Arun District Council
Arun Civic Centre
Maltravers Road
Littlehampton
West Sussex BN17 5LF
Planning & Building Control General Enquiries
Tel: (01903) 737756 Fax: (01903) 730442
Dx: 57406 Littlehampton
Minicom: 01903 732765
e-mail: planning@arun.gov.uk
website: www.arun.gov.uk/planning

Application No: A/84/21/DOC
Site Address: Land South of Water Lane Angmering
Description of works: Approval of details reserved by condition imposed under ref A/99/17/OUT relating to Condition Nos 23 - maintenance & management of sustainable drainage scheme (SuDs), 24 - foul water sewerage disposal, 25 - discharge flows to watercourses, 26 - future access & maintenance of any watercourse or culvert and 28 - Flood Risk Assessment & surface water drainage strategy.

Thank you for your internet representation made on 3rd June 2021 which has been recorded as an objection with the comments as follows:

Drawing Issue Status					
FOR APPROVAL					
WATER LANE, ANGMERING PROPOSED BOX CULVERT WSCC REF: 1772 GENERAL ARRANGEMENT					
Client			  		
Date of 1st Issue 29.10.2020		Designed HJ	Drawn JS		
A1 Scale As Indicated		Checked HJ	Approved PC

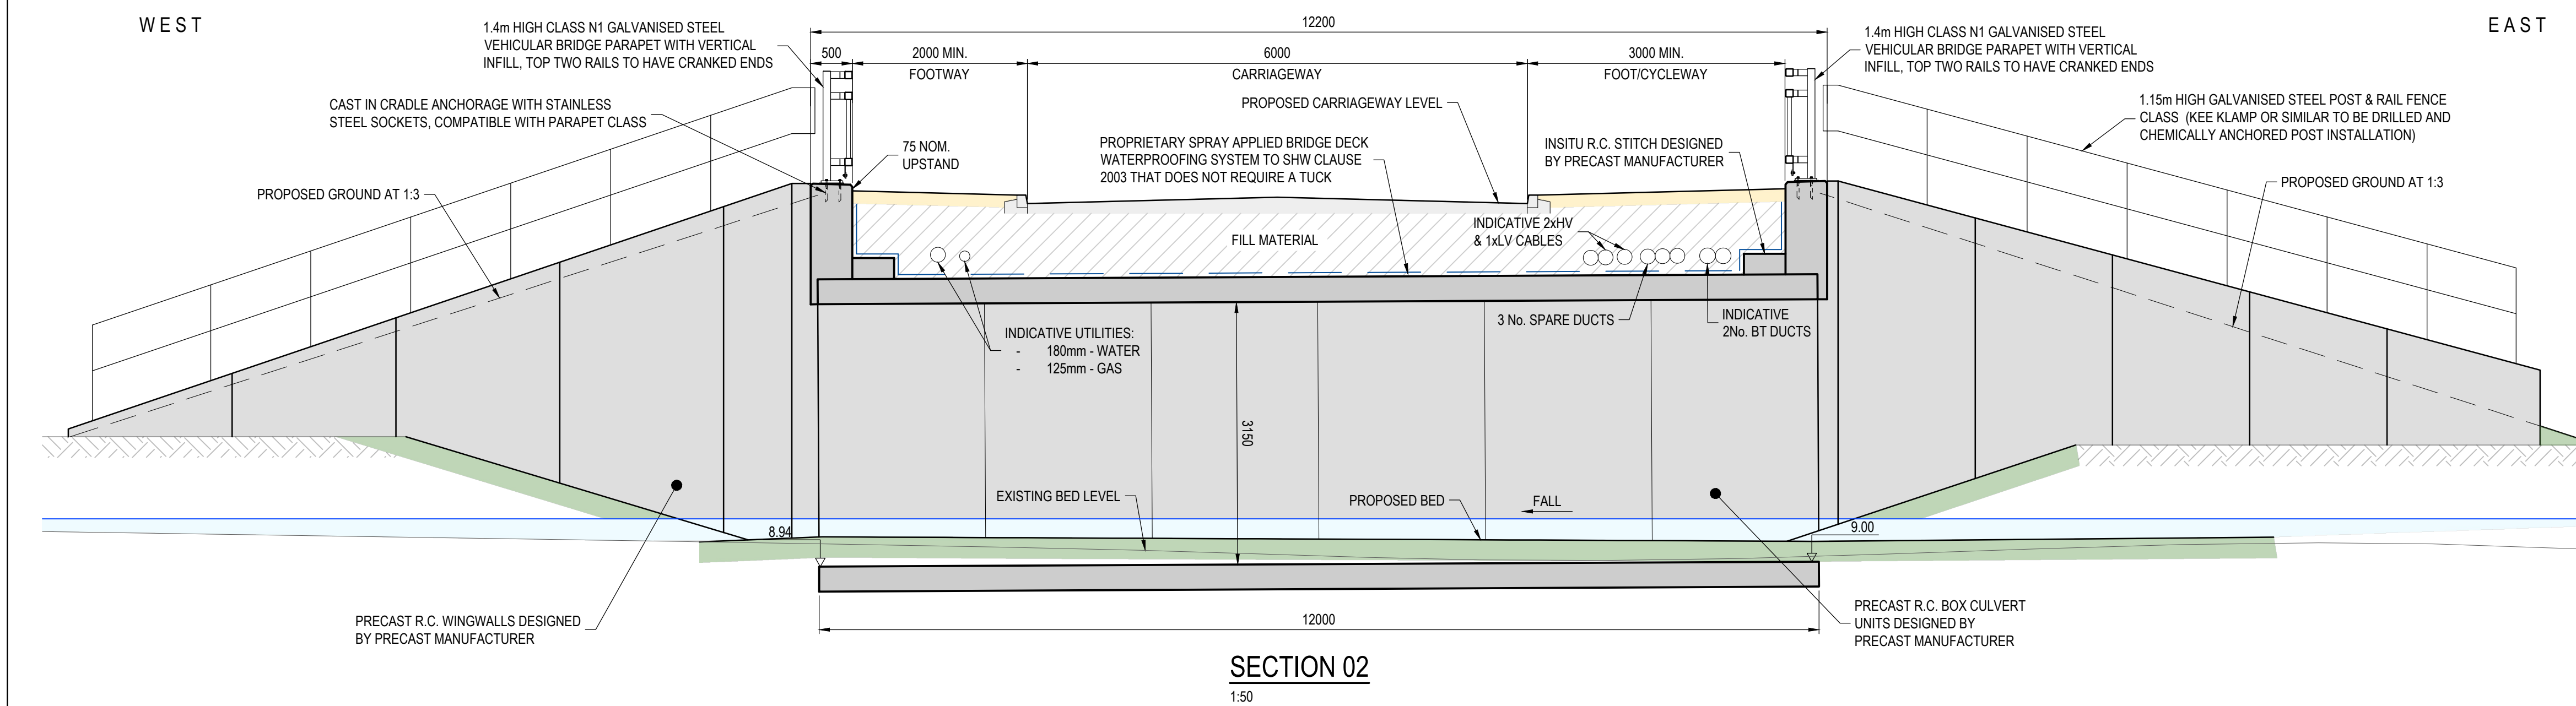
Observations and comments of Council's Drainage Engineer and Geoff Gibbs to be resolved, Southern Water also has asked for an extension of time. Clearly approval of the culvert details would be premature as alterations to the design will be required when the flow control weir details are known. No confirmation on SUD maintenance schedule of who will be responsible for the detailed schedule.
